# Appeal Decision

**Appeal Ref: APP/R5510/W/22/3301457**

**46 Laurel Lane, West Drayton UB7 7TX**

- The appeal is made under section 78 of the Town and Country Planning Act 1990 against a failure to give notice within the prescribed period of a decision on an application for planning permission
  - The appeal is made by Mr Jawad Ahmed against the Council of the London Borough of Hillingdon.
  - The application Ref 17506/APP/2021/4043, is dated 1 November 2021.
  - The development proposed is two storey side and rear extension and single storey rear extension.
-

Block Plan

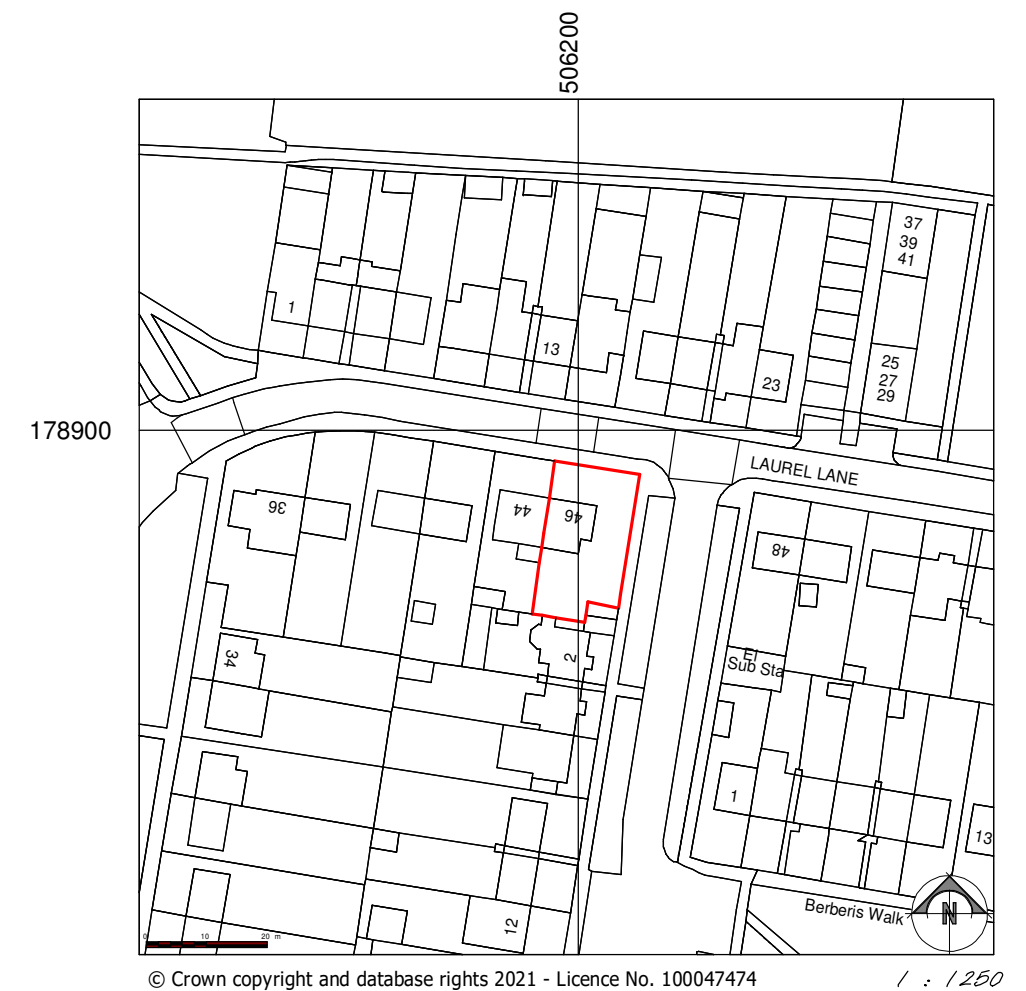
4. To the side of the appeal dwelling, the proposed extension would be closer to Berberis Walk than neighbouring buildings to the rear which face this street. However, the established building line along Berberis Walk is not uniform, with buildings stepping generally forward towards the junction, and the step forward of the appeal development would not be significantly larger than these steps. Taken in isolation, I do not therefore consider that the projection of the extension beyond the Berberis Walk building line would necessarily be unacceptable.

DRAWN: DAF	SCALE: 1 : 50 @ A3	DATE: October '21
DRAWING NO: 21/457/05	REV: A

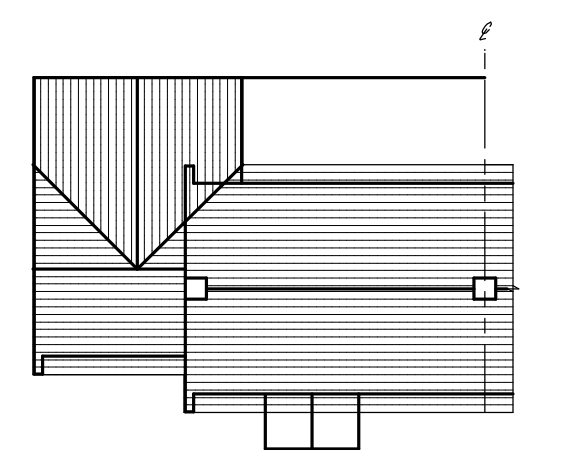
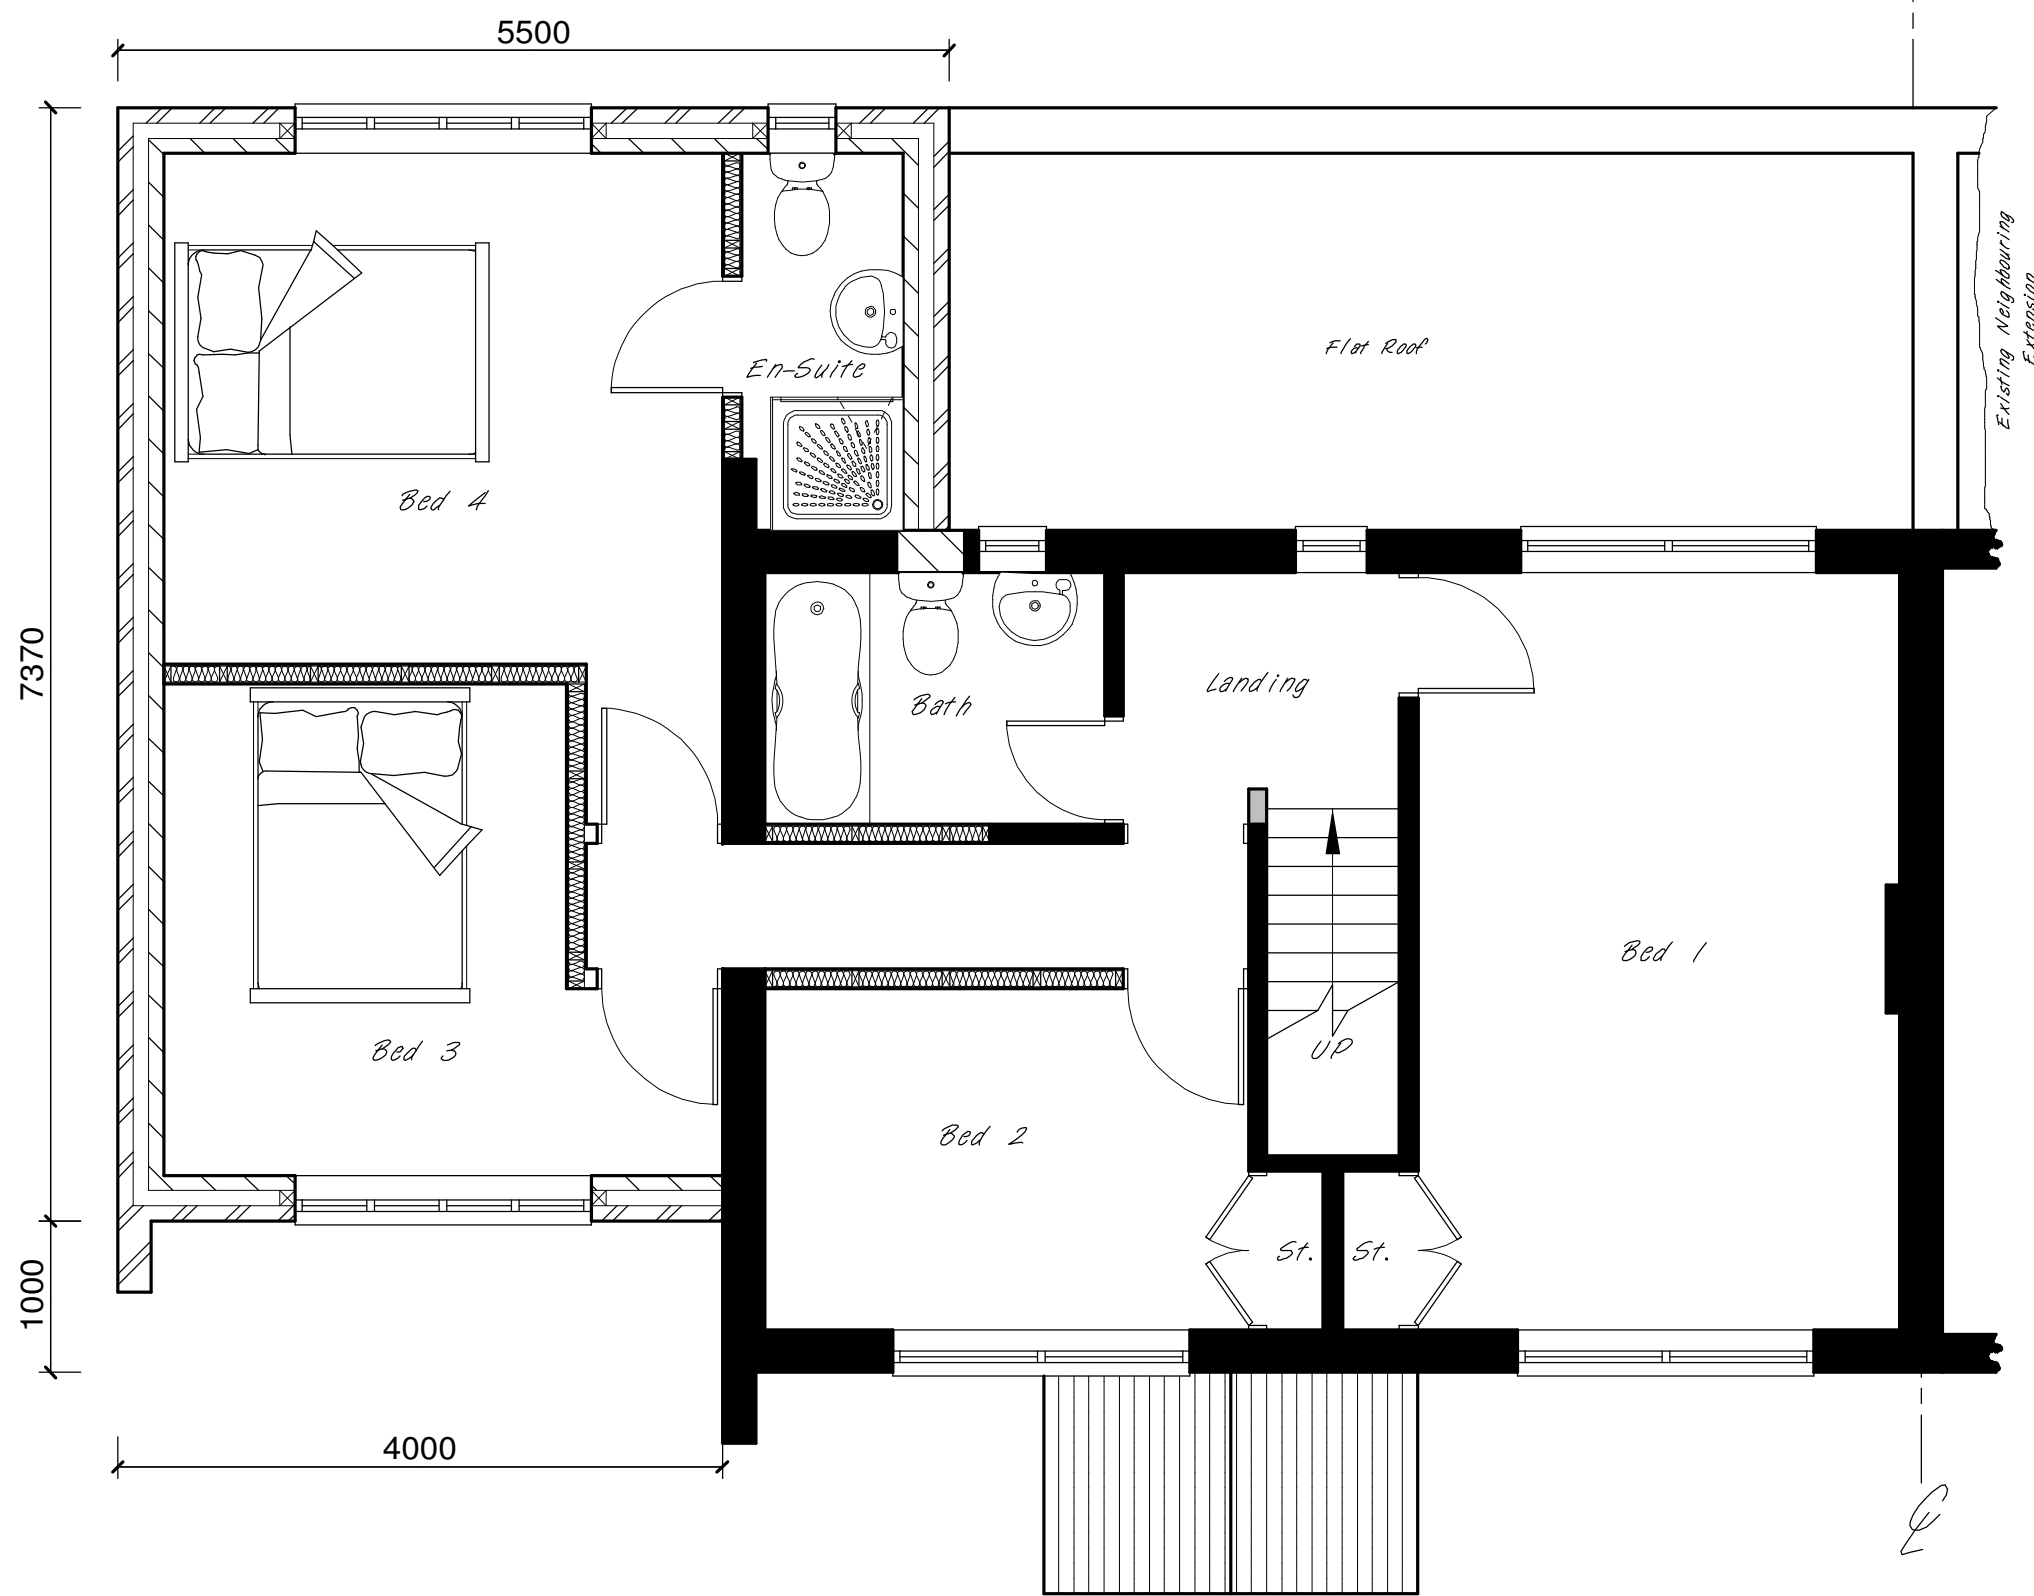
5. However, the extension would wrap around to the rear of the dwelling at two-storey level. Its width at the rear would be more than half the width of the host dwelling, contrary to one of the requirements for side extensions within Policy DMHD 1 of the Local Plan: Part 2 – Development Management Policies 2020 ('LPP2'), and it would also be of greater overall depth than the host

dwelling. I acknowledge that the gables to the side and rear of the extension would be consistent with the existing roof form, but they would be only slightly lower than the main roof and would add further bulk to the upper parts of the extension. Coupled with the large overall width and depth of the extensions relative to the host dwelling, I find that the proposal would result in an excessively bulky and disproportionate addition that would dominate the host dwelling. As a consequence, there would be detriment to its architectural integrity, character and appearance.

DRAWN: DAF	SCALE: 1 : 100 @ A3	DATE: October '21
DRAWING NO: 21/457/06		REV: A

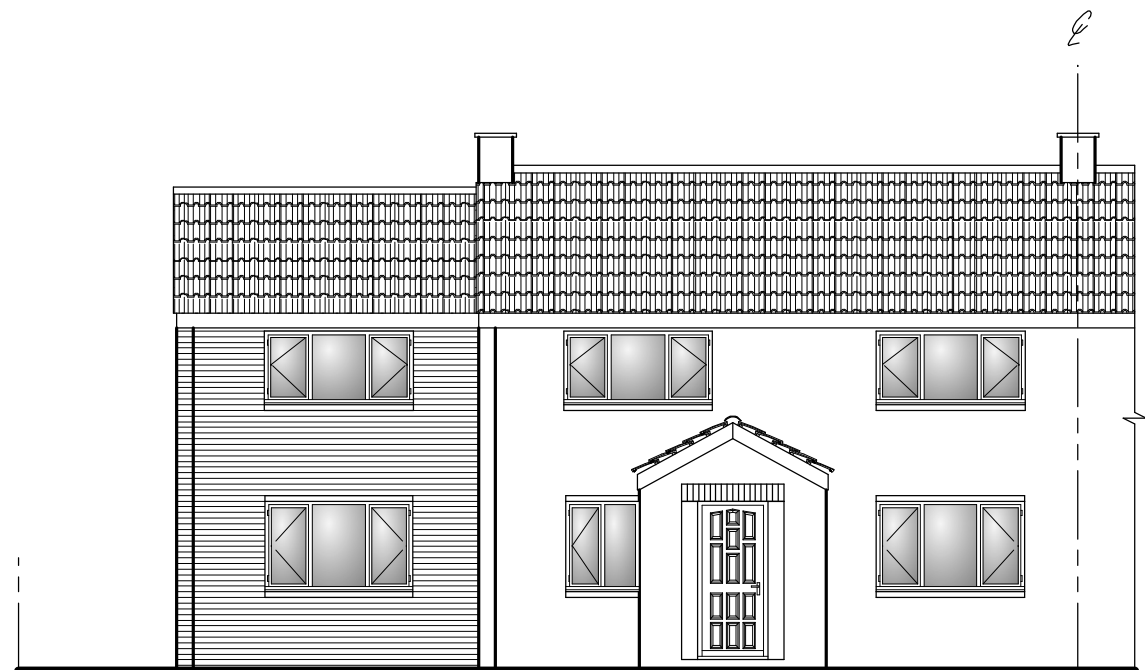
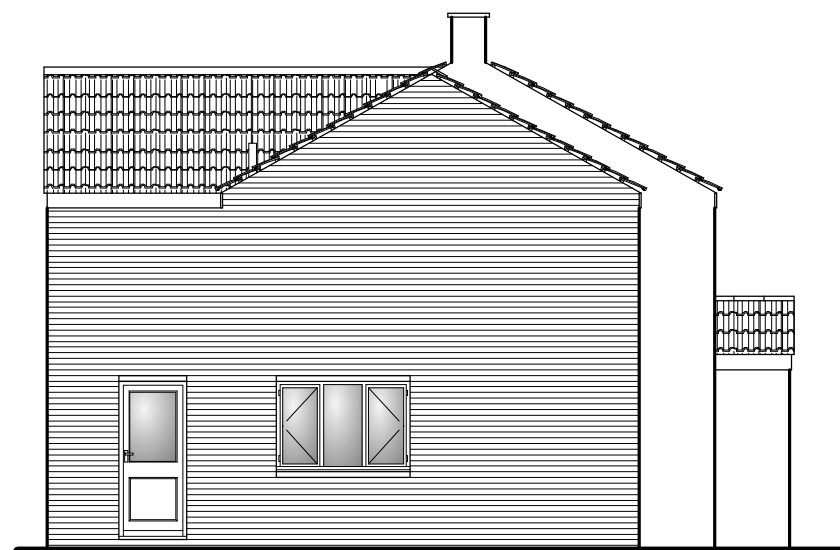
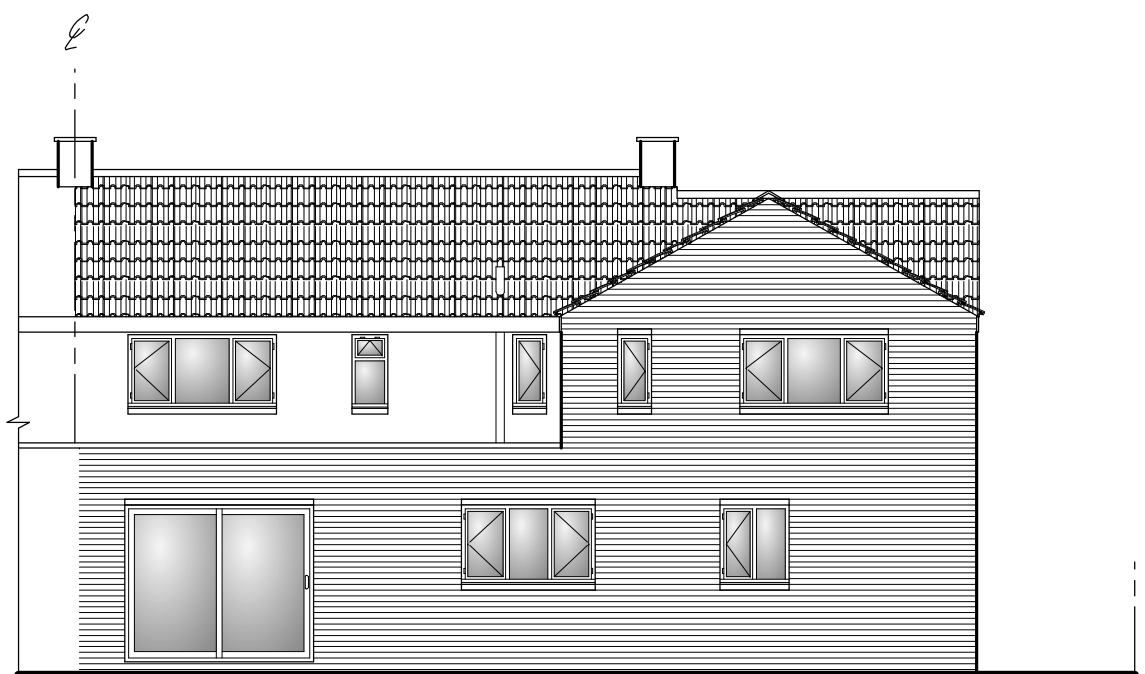
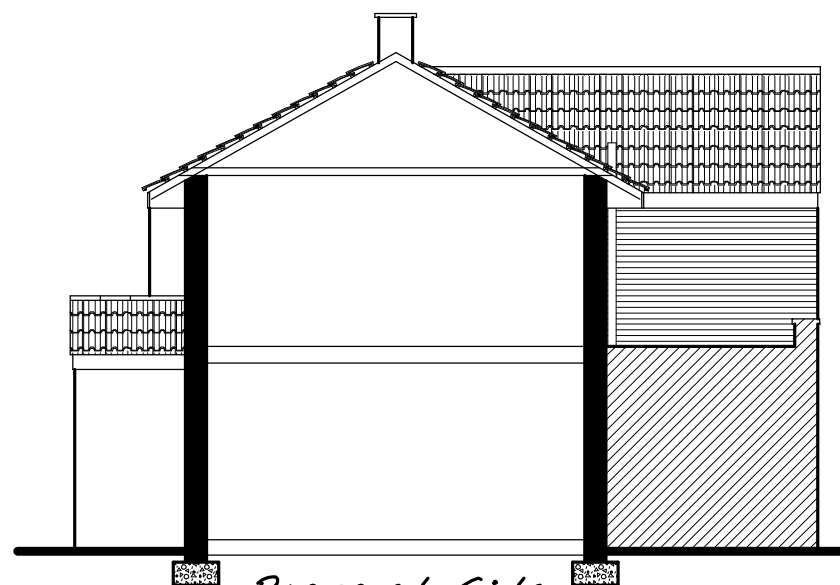
6. Moreover, the development would be visible from both Laurel Lane and Berberis Walk, and would be particularly prominent in views along Berberis Walk as a result of its position partly forward of the adjacent dwellings to the rear. In these views, I find that the large overall bulk and mass of the development would erode the distinctive spaciousness around the corner, and would stand out as a discordant and intrusive feature. The proposal would also therefore harm the character and appearance of its surroundings.
